M3 Junction 9 Improvement

Scheme Number: TR010055

8.16 Applicant Comments on Deadline 3 Submissions

18 August 2023

**FIGURE 8A**  
**Tree Removal Plan &**  
**LVIA Viewpoints**

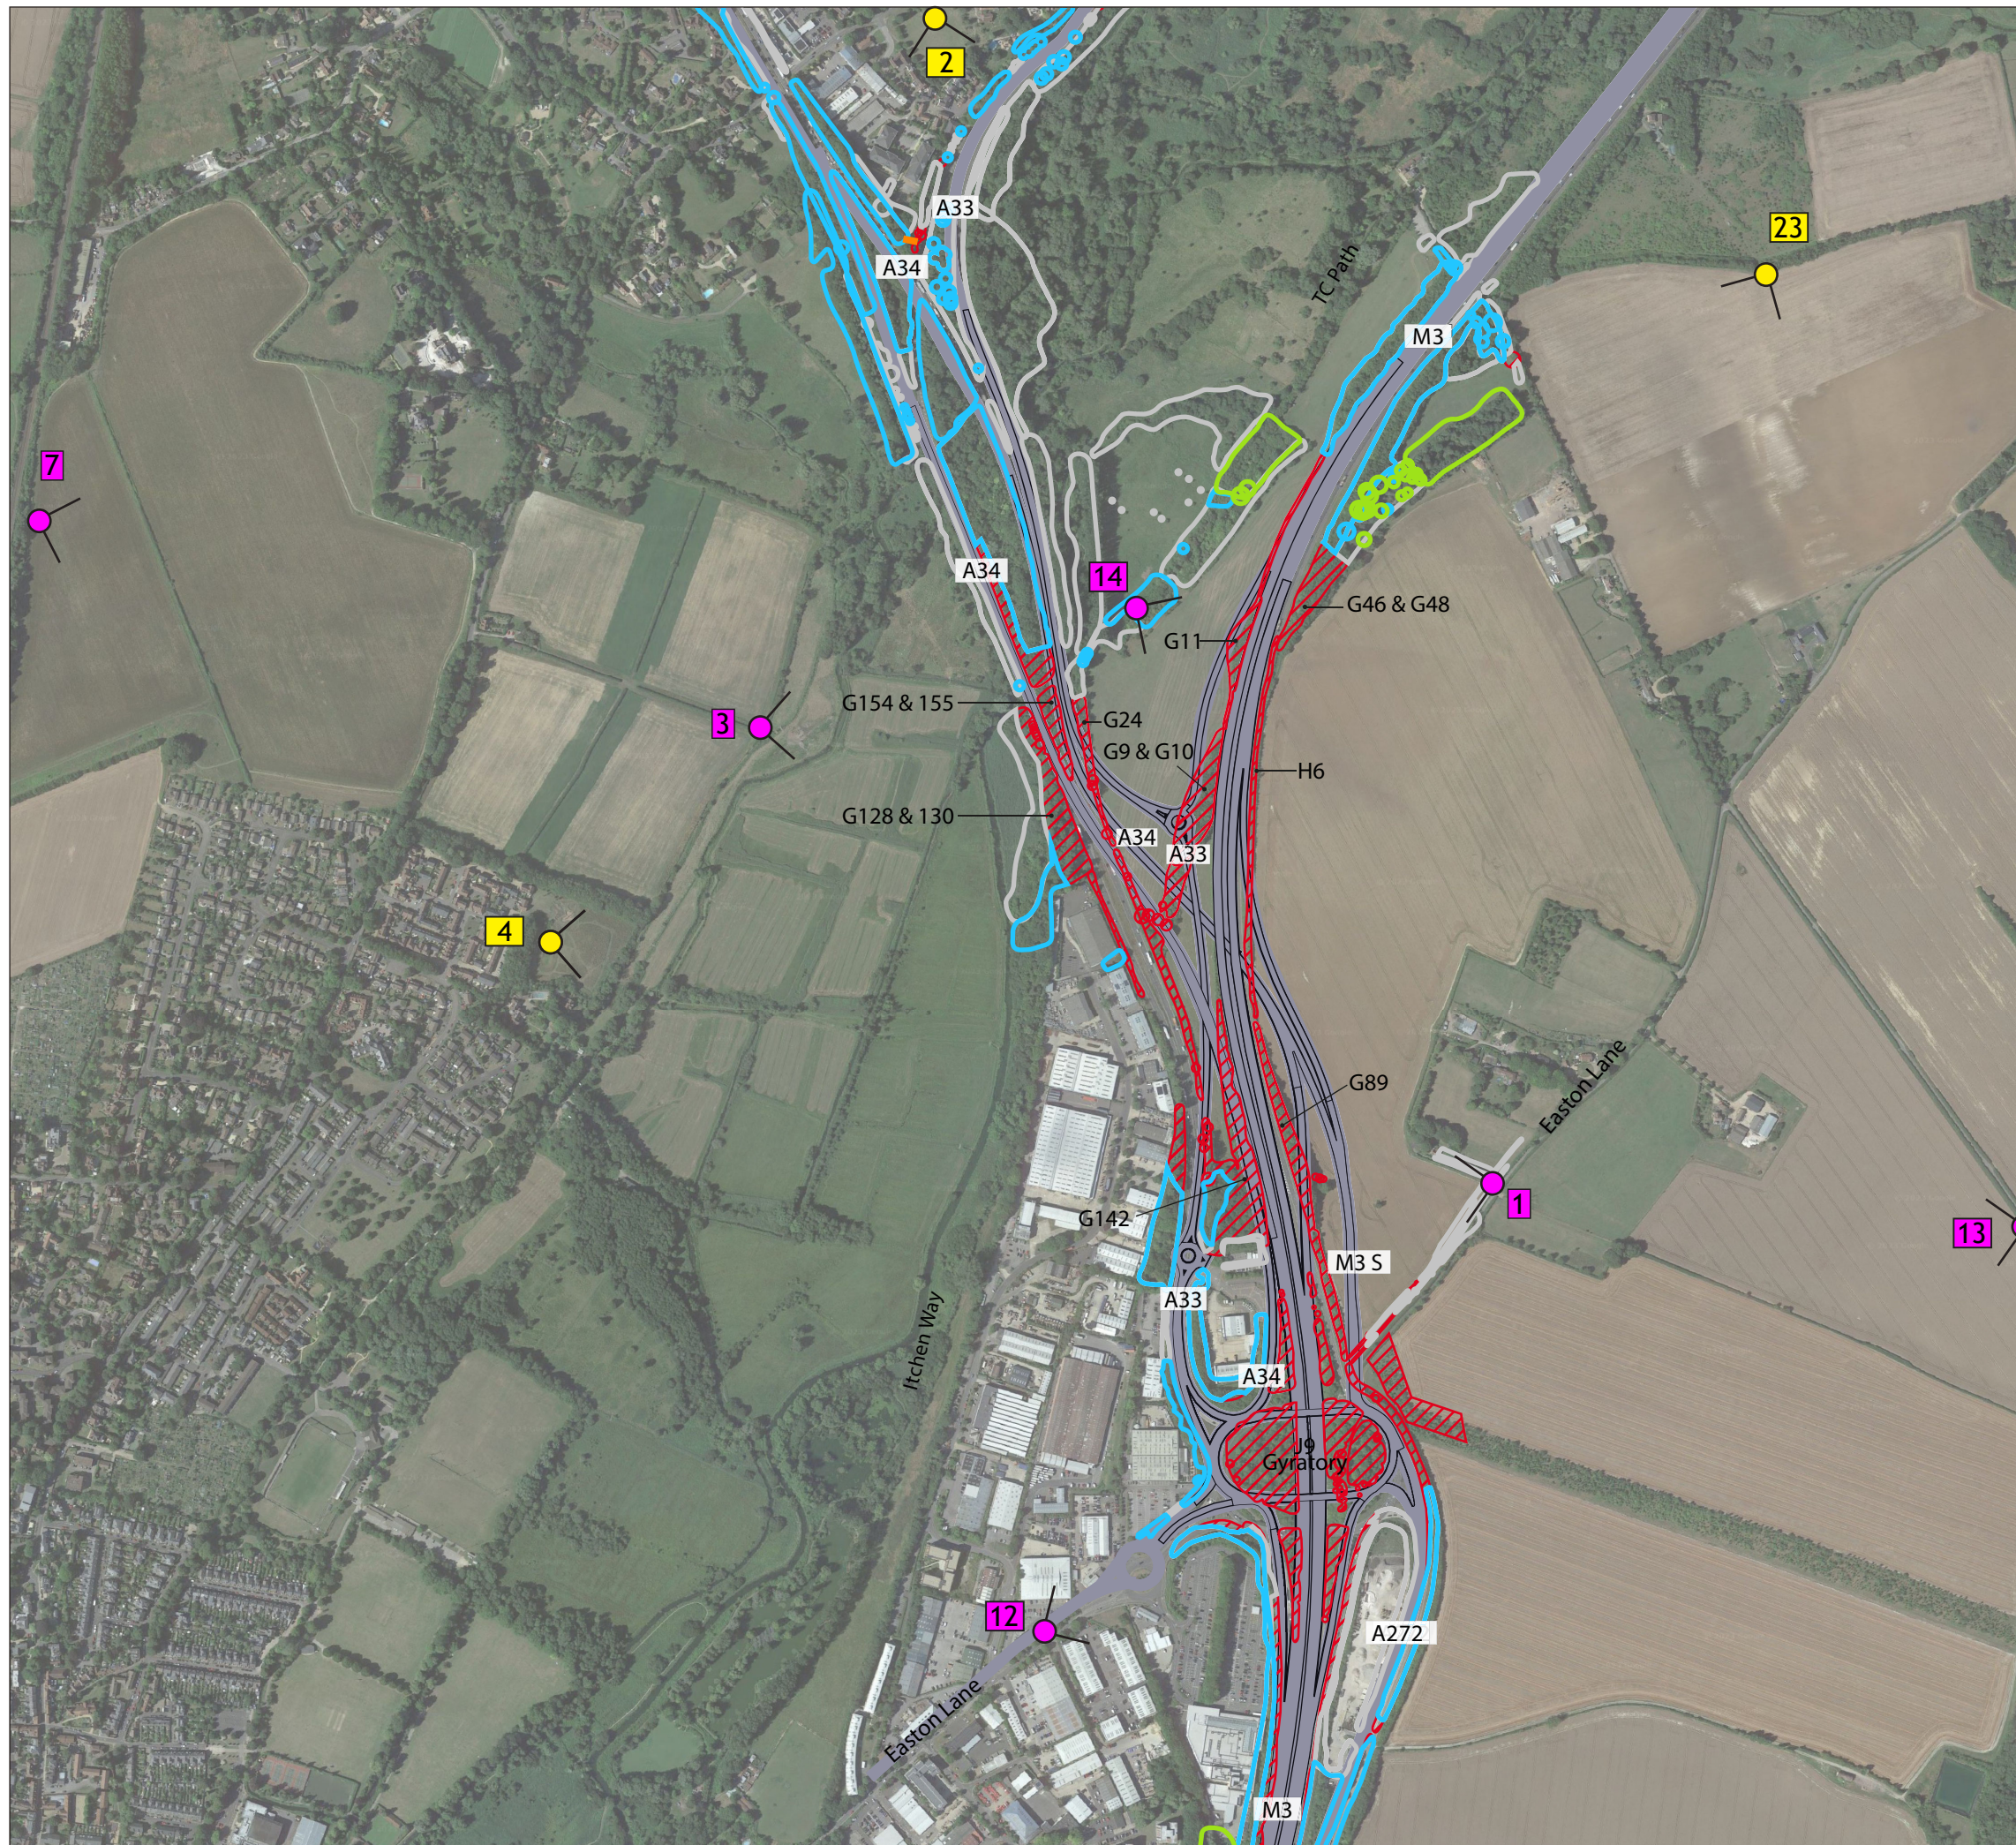
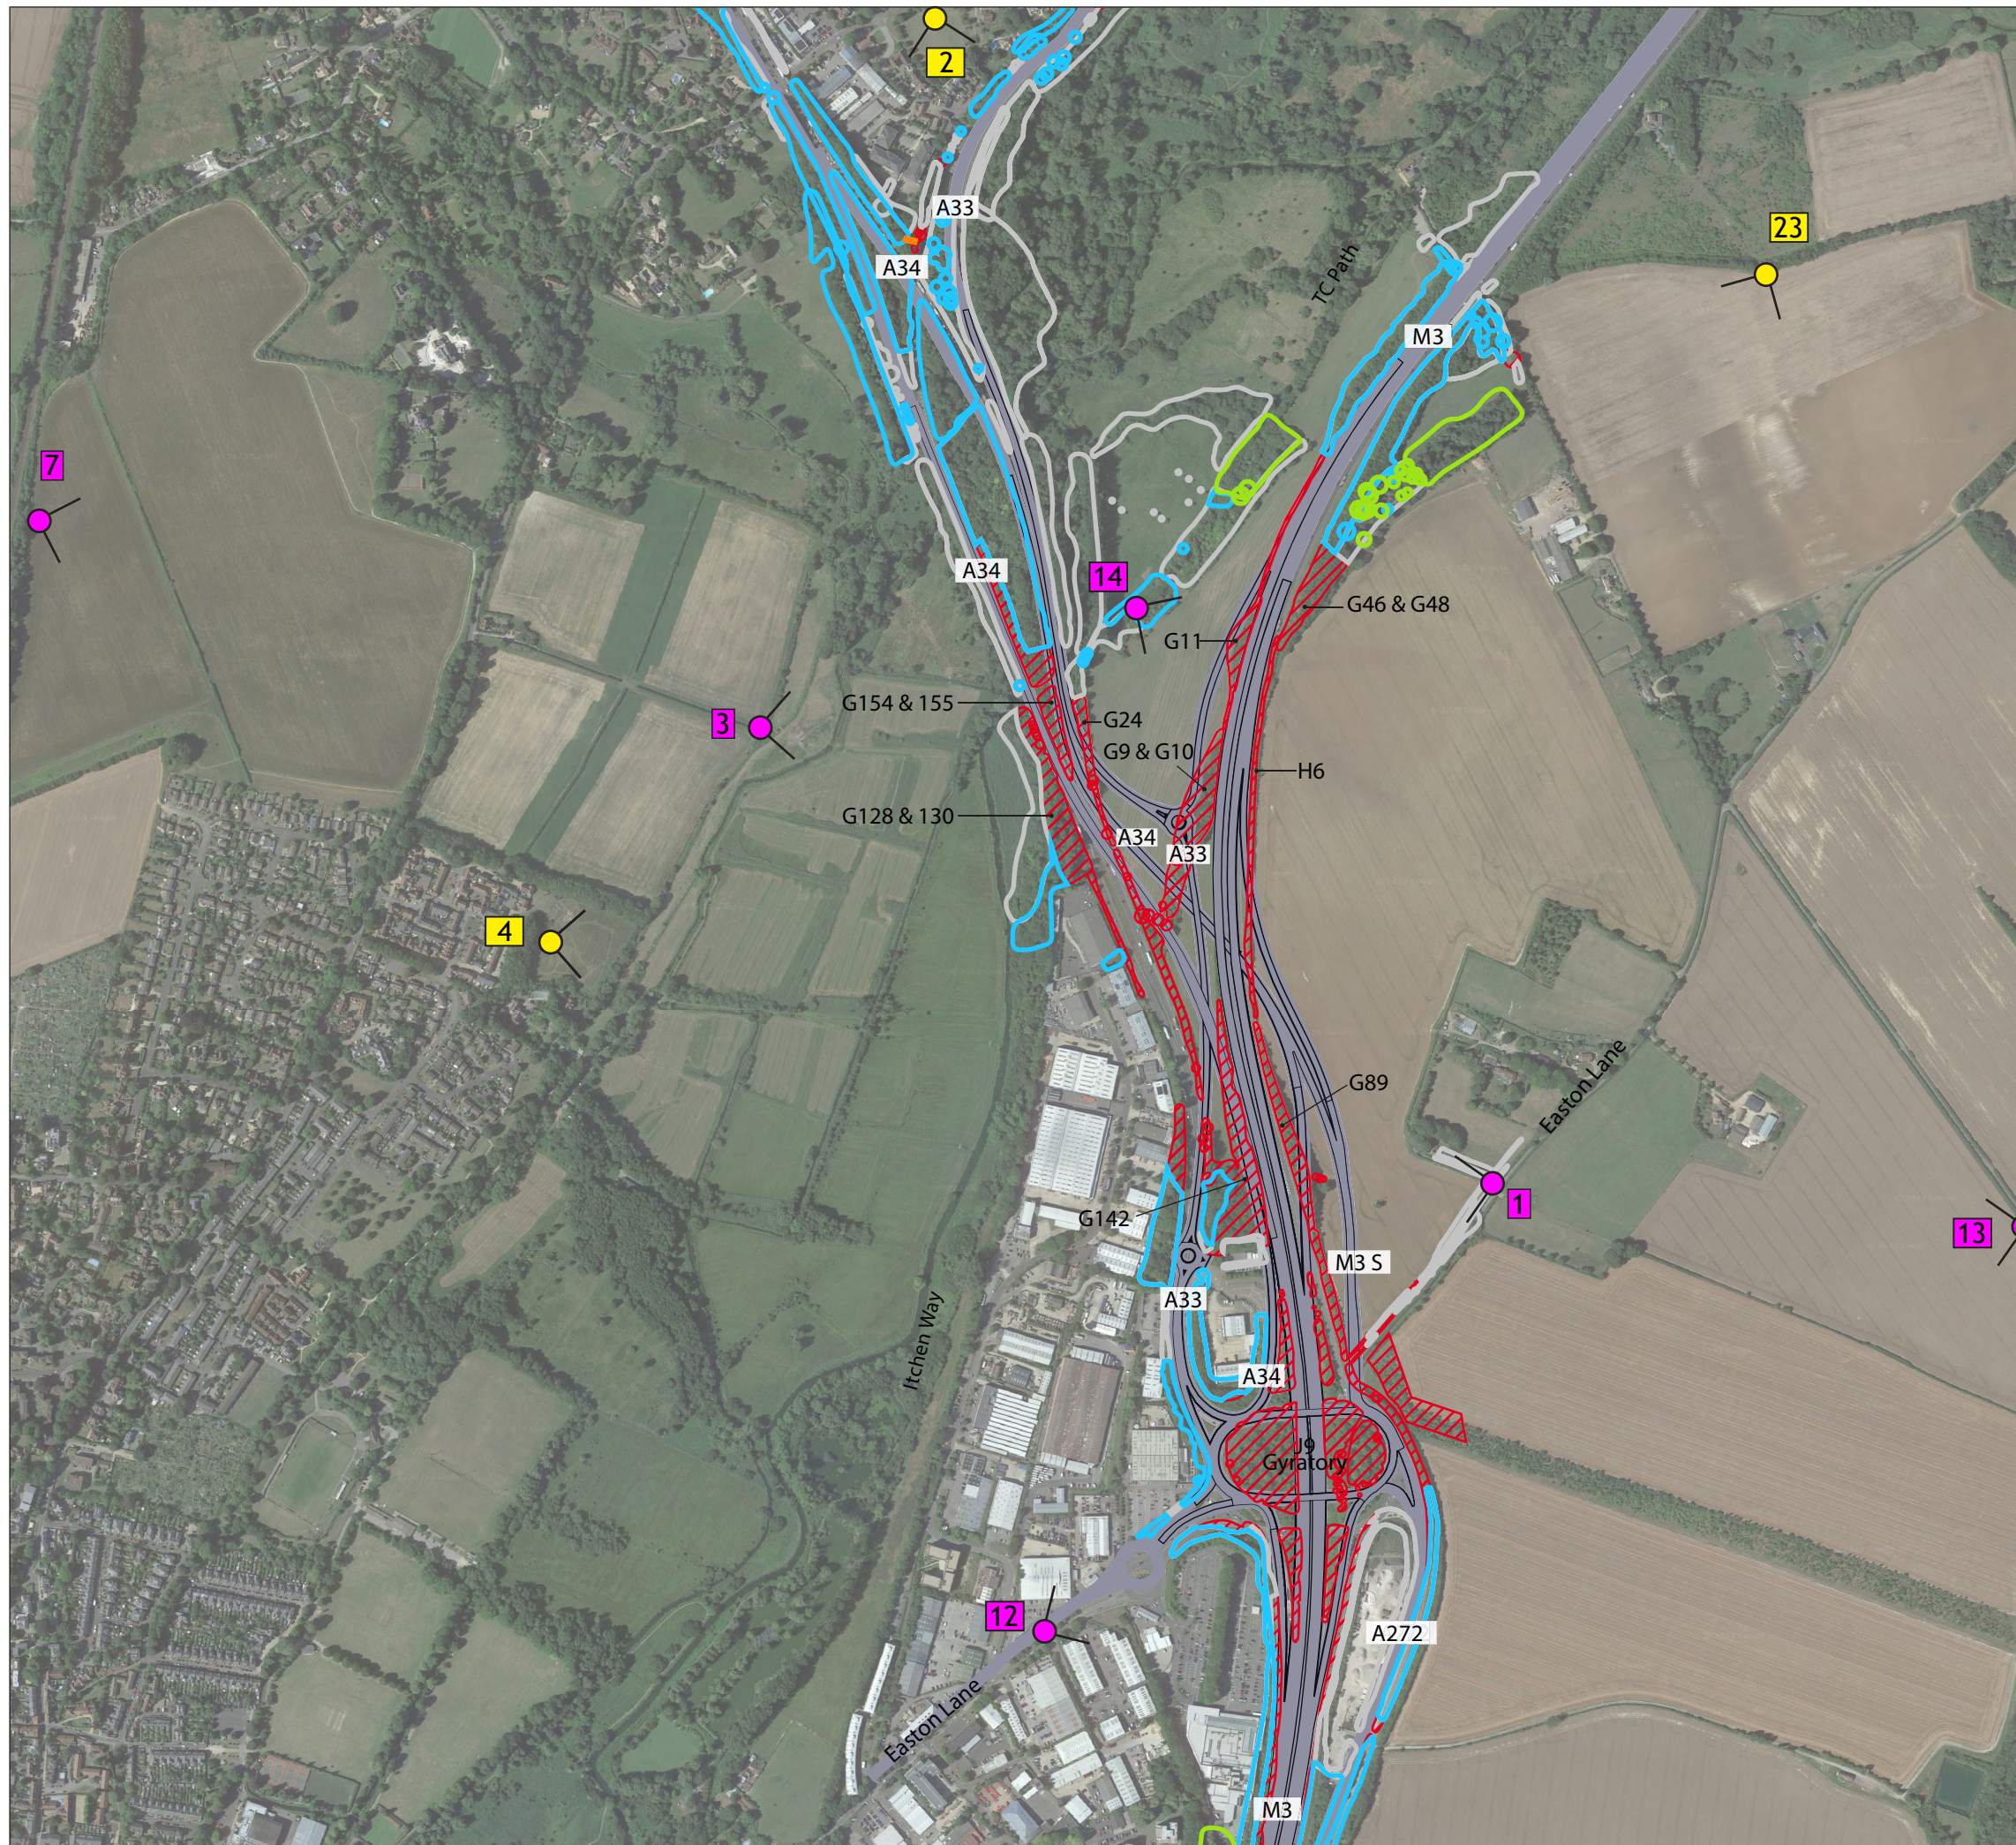
Twyford Parish Council	Applicant Response
Figure 8A – Tree Removal Plan and LVIA Viewpoints	The Applicant notes that this is a figure produced by South Downs National Park Authority using information from

Twyford Parish Council	Applicant Response
	<p>Appendix 7.5 (Preliminary Arboricultural Impact Assessment) of the ES (6.3, APP-101). The Applicant has no further comments.</p>
<p>Figure 9A – Environmental Masterplan and LVIA Viewpoints</p>	<p>The Applicant notes that this is a figure produced by South Downs National Park Authority using information from Figure 2.3 in Chapter 2 (The Scheme and its Surroundings – Figures (Part 2 of 4)) of the ES (6.2, APP-062). The Applicant has no further comments.</p>
